Subject: RE: Planning Consultation on BN/17/20/DOC

Engineers Comments Regarding Surface Water Drainage

Site Address: Westray 3 Oriel Close Barnham PO22 0HN

Description of Works: Approval of details reserved by condition imposed under ref BN/92/19/HH relating to Condition No 3 - surface water drainage scheme

PROPOSED DRAINAGE PLAN

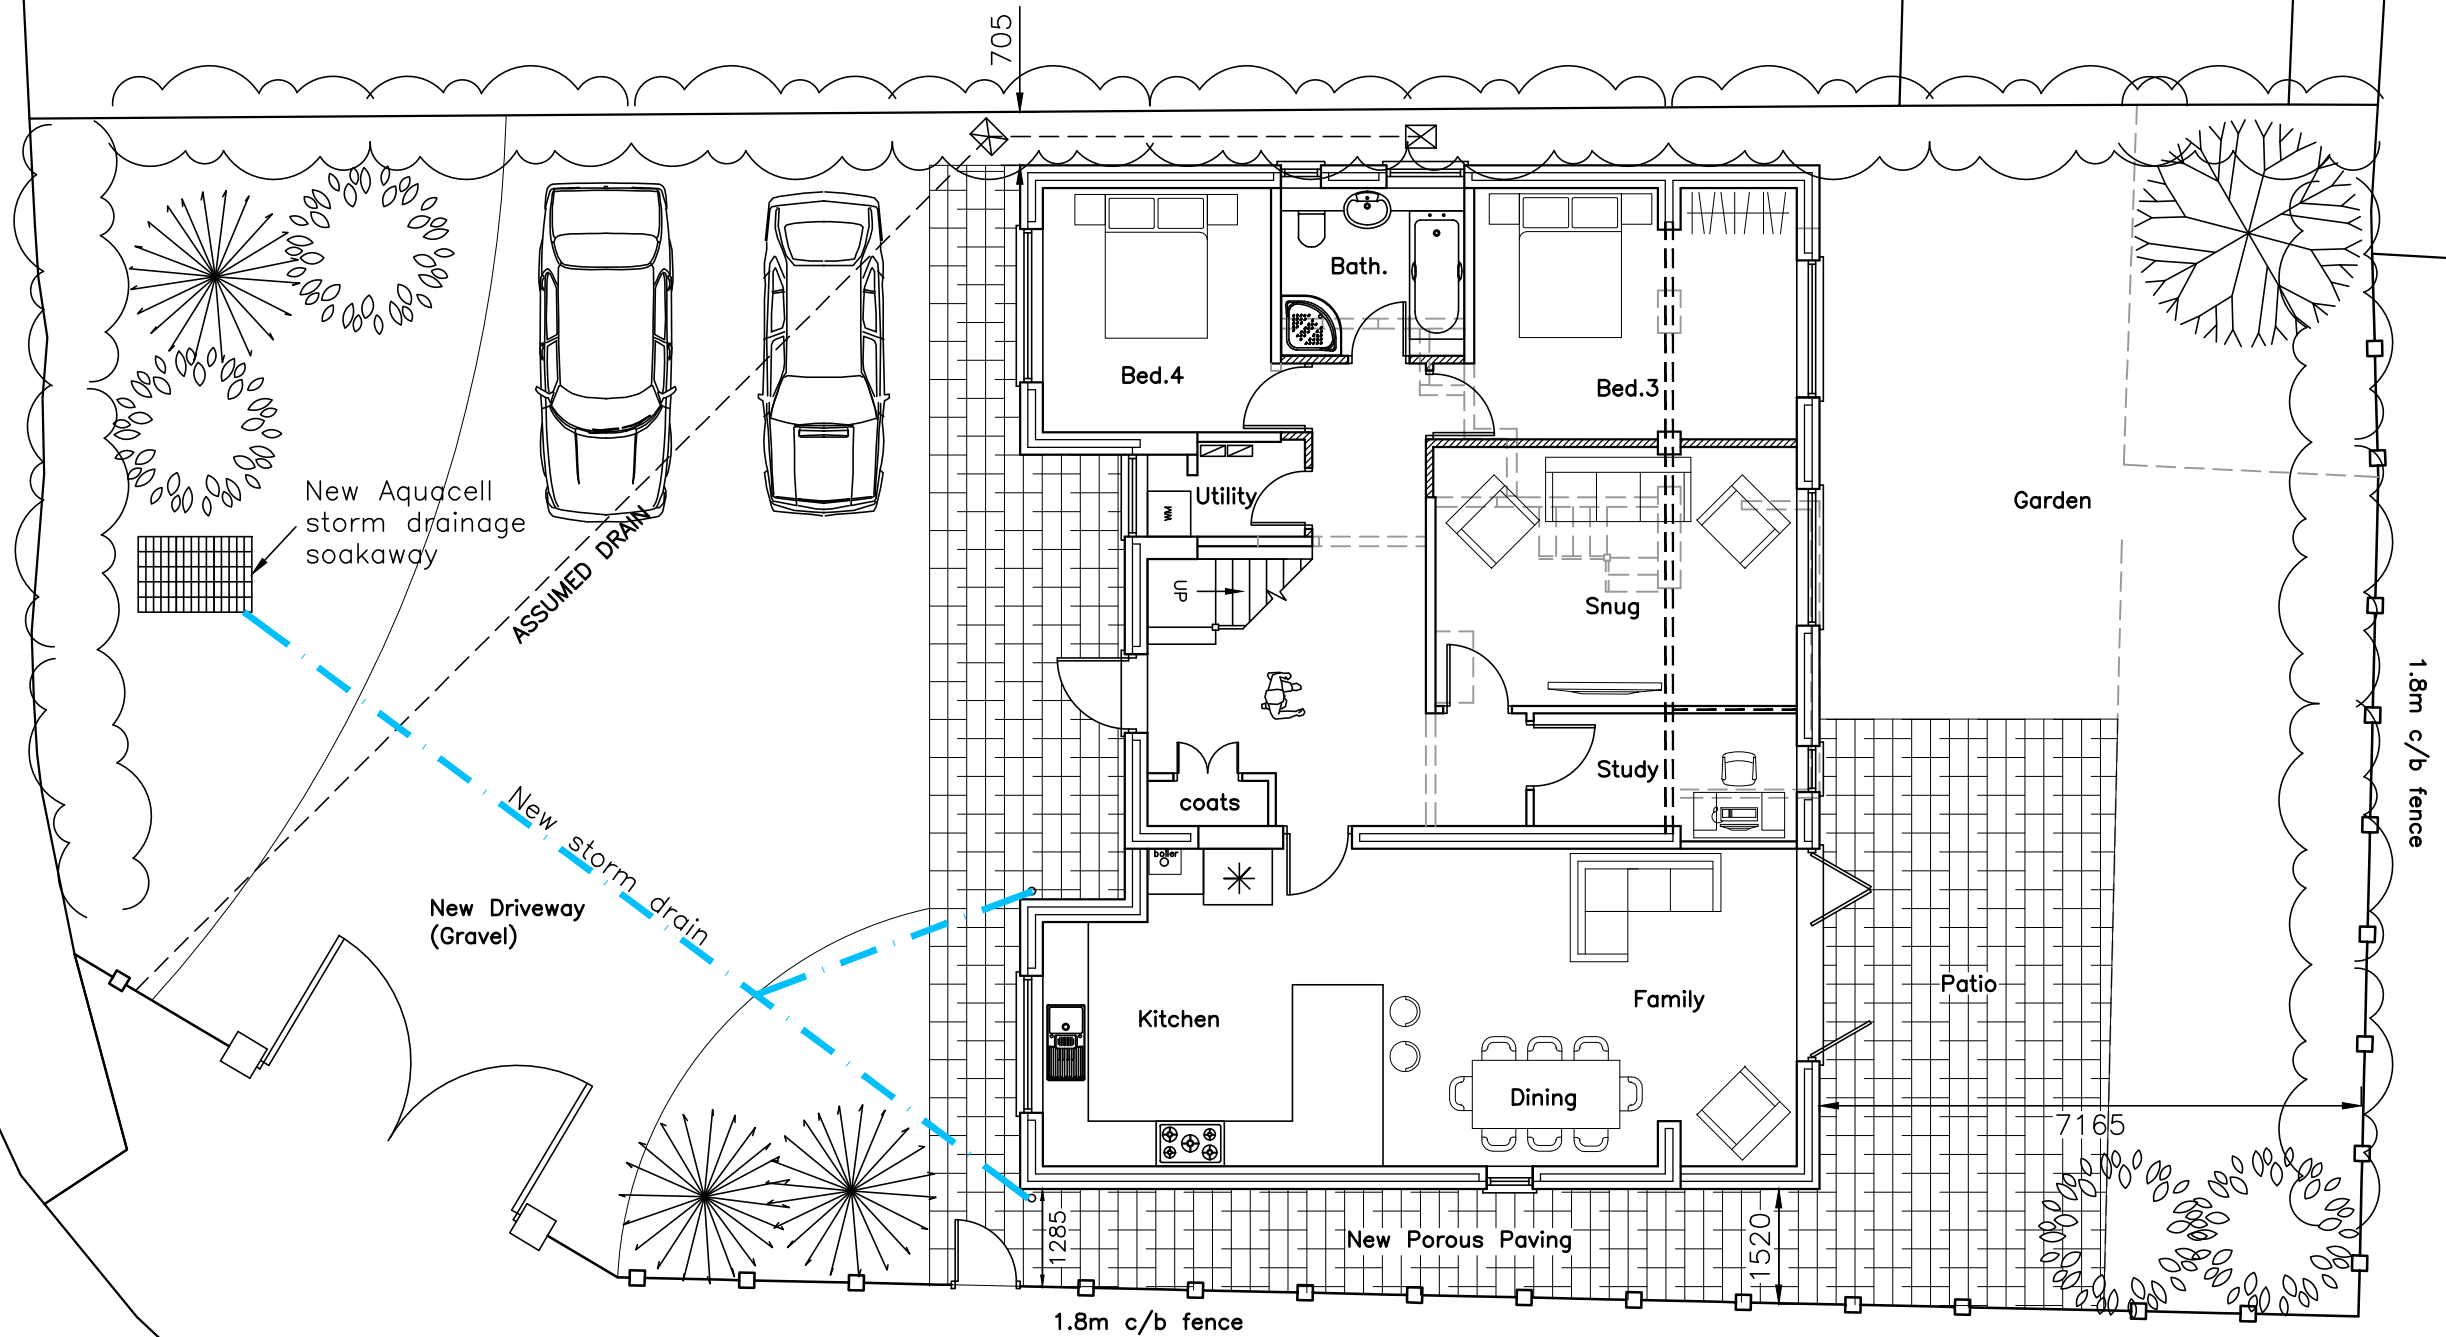
In addition, as previously stated further detail is expected on the drainage layout. We would expect to see detail drawings for each component (structures, silt traps, pipe and surround). This will be the same level of detail if the applicant as to attenuate on site and discharge to a watercourse or surface water sewer (in this case we would also need to see a detail of flow control device to limit flow to no more than 5l/s).

CLIENT MR JAMES TAYLOR					
ARCHITECT CRITCHLEY ARCHITECTURE AND DESIGN LTD					
JOB TITLE 3 ORIEL CLOSE BARNHAM					
DRAWING TITLE SURFACE WATER DRAINAGE LAYOUT					
DRAWN LH	ENGINEER CS	CHECKED	APPROVED		
DATE MAY 2020	SCALE @ A1 1:100				
JOB No. C1375	STATUS P	DRAWING No. 100	REV. P1

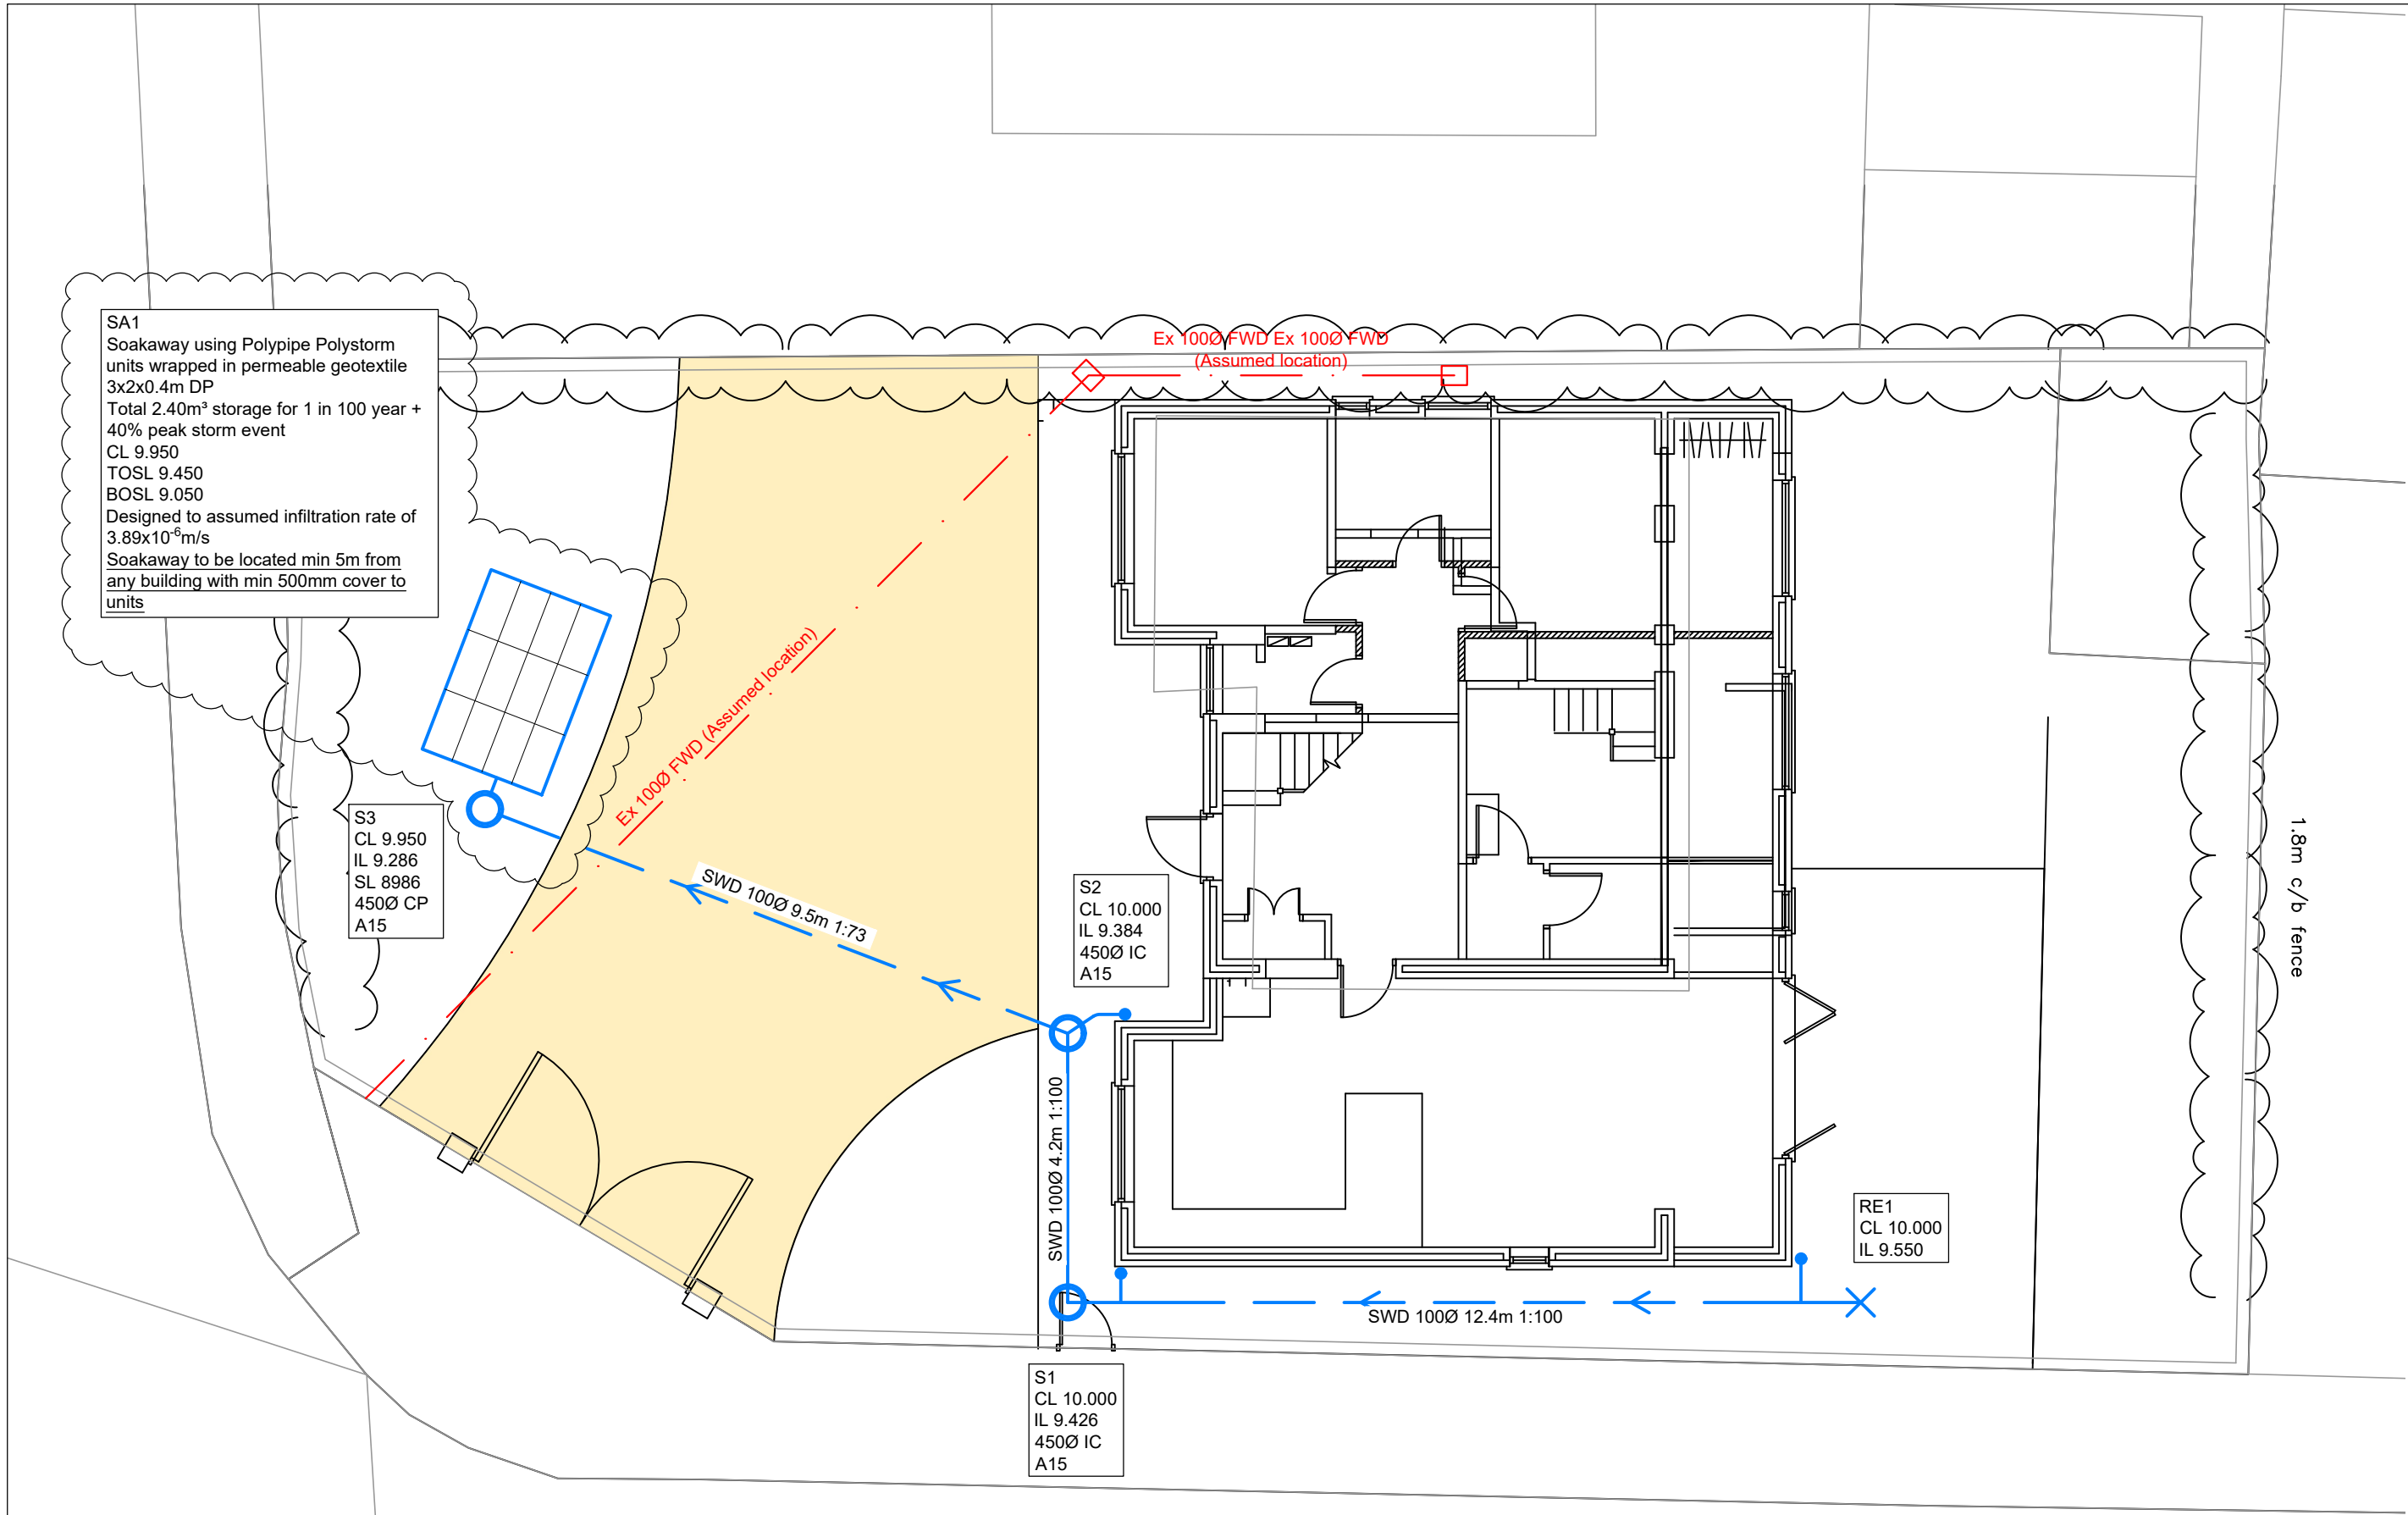
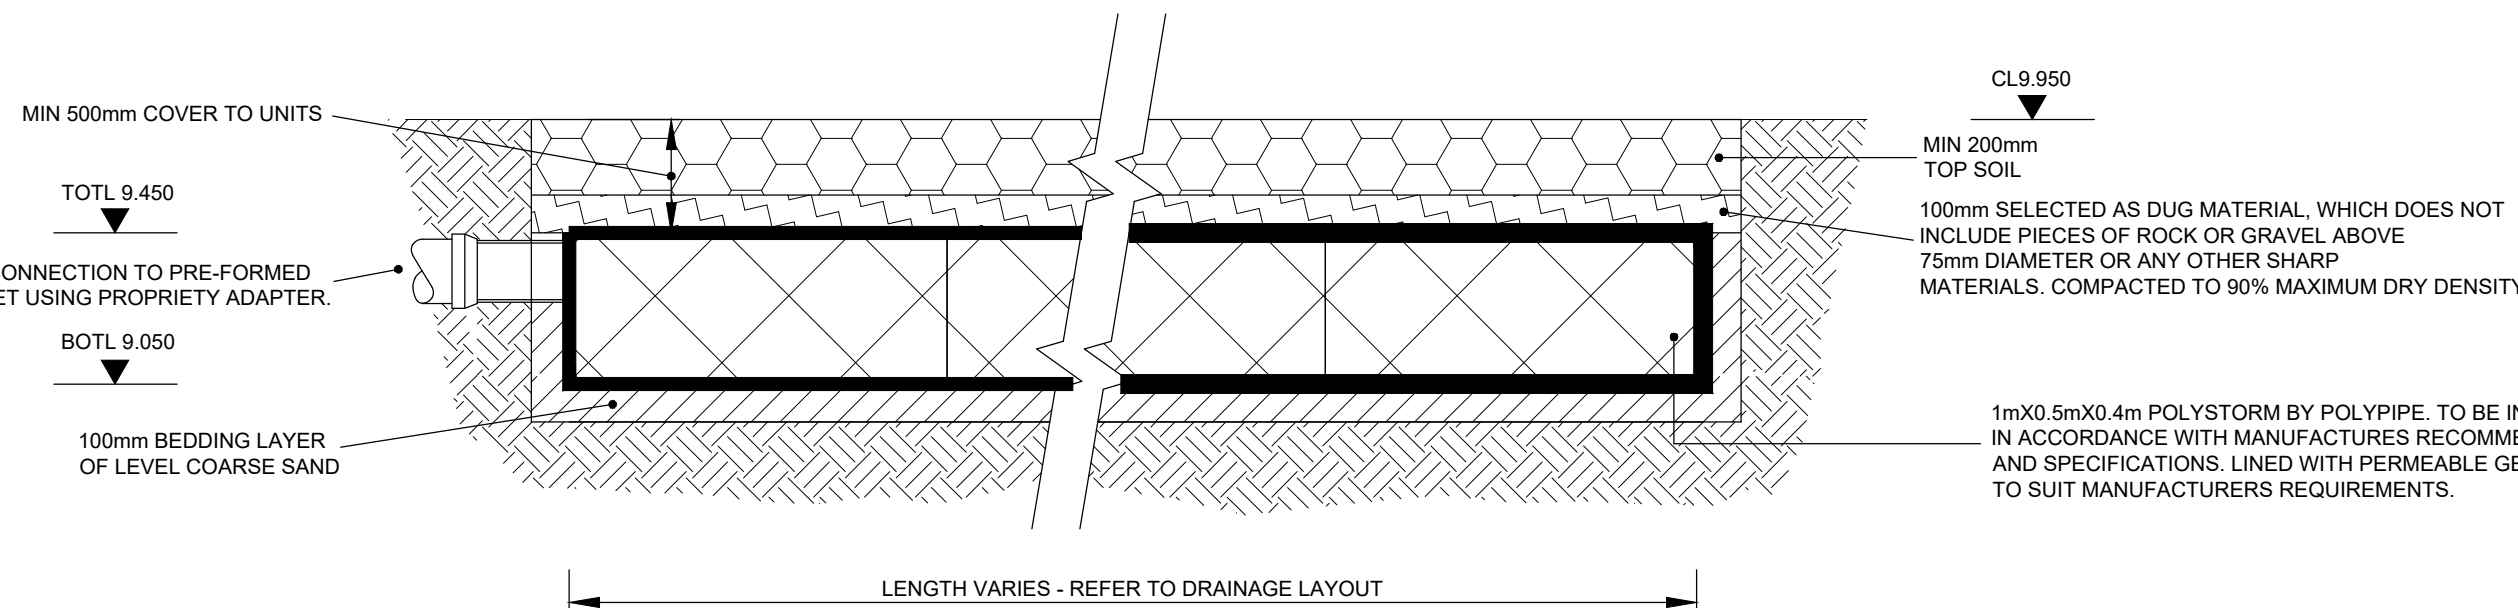
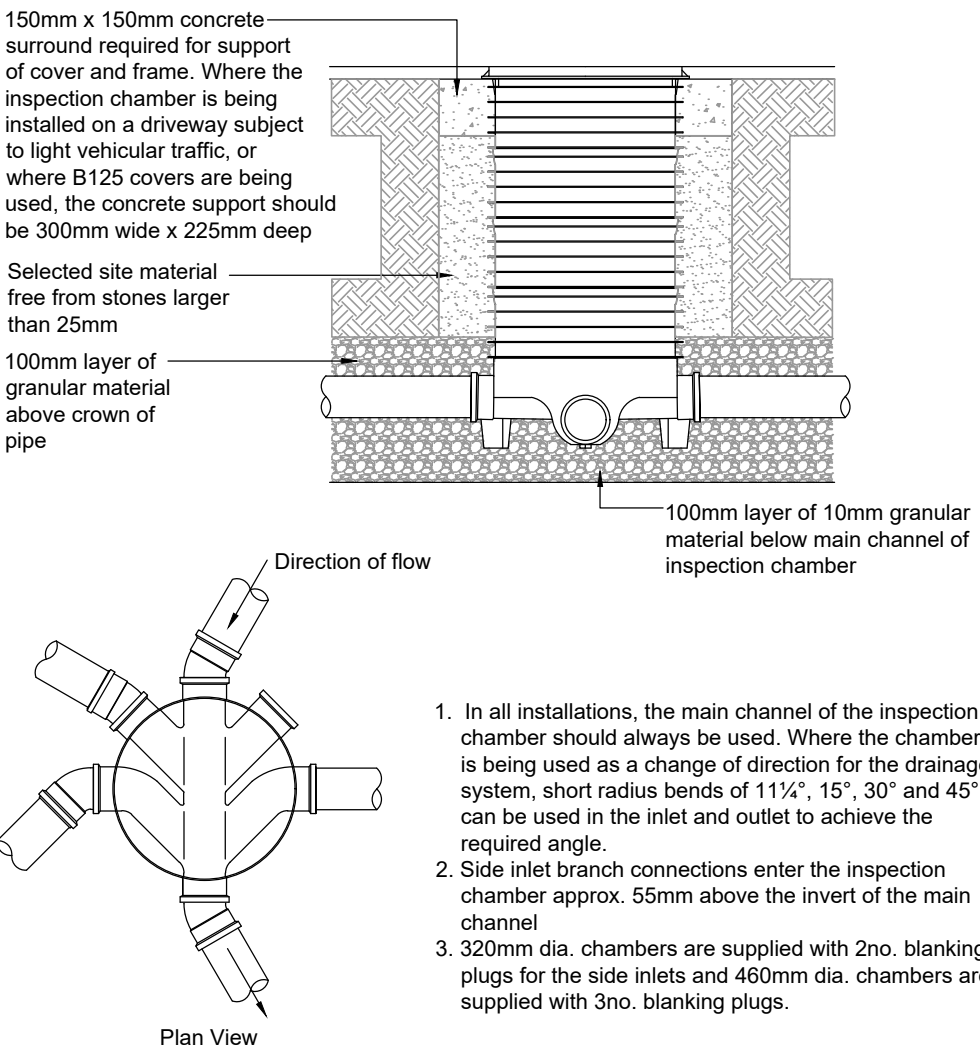
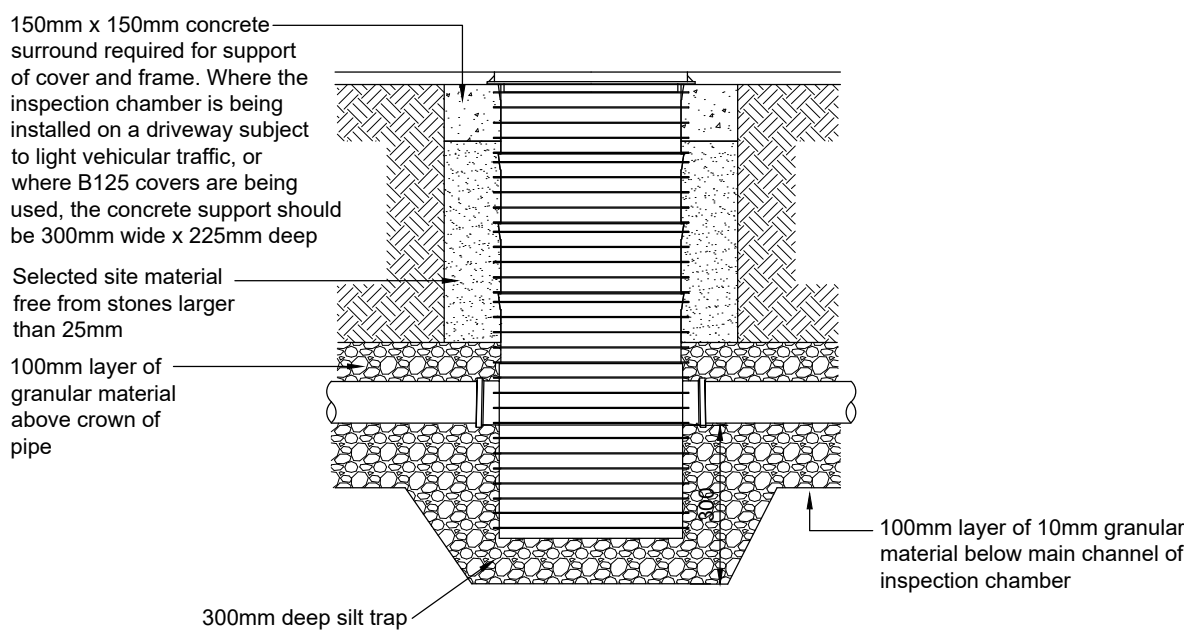
This is the third time that this proposal has been assessed. In this case the submitted details amount to less detail than the last submission as part of the initial planning application. On this occasion no groundwater monitoring data has been provided (previously stated on a drainage checklist to be at 0.3mbgl). There is insufficient detail of infiltration testing (date, depth of pit, repeat tests) and the test completed was not in accordance with BRE365 as the trial pit was undersized (should be minimum 0.3m x 1m). On a previous assessment the site investigation results appeared to show that infiltration was not viable and yet this is still the proposed solution with no evidence provided to contradict the previous submission.

As previously stated the calculations do not appear to use BRE365 for their method.
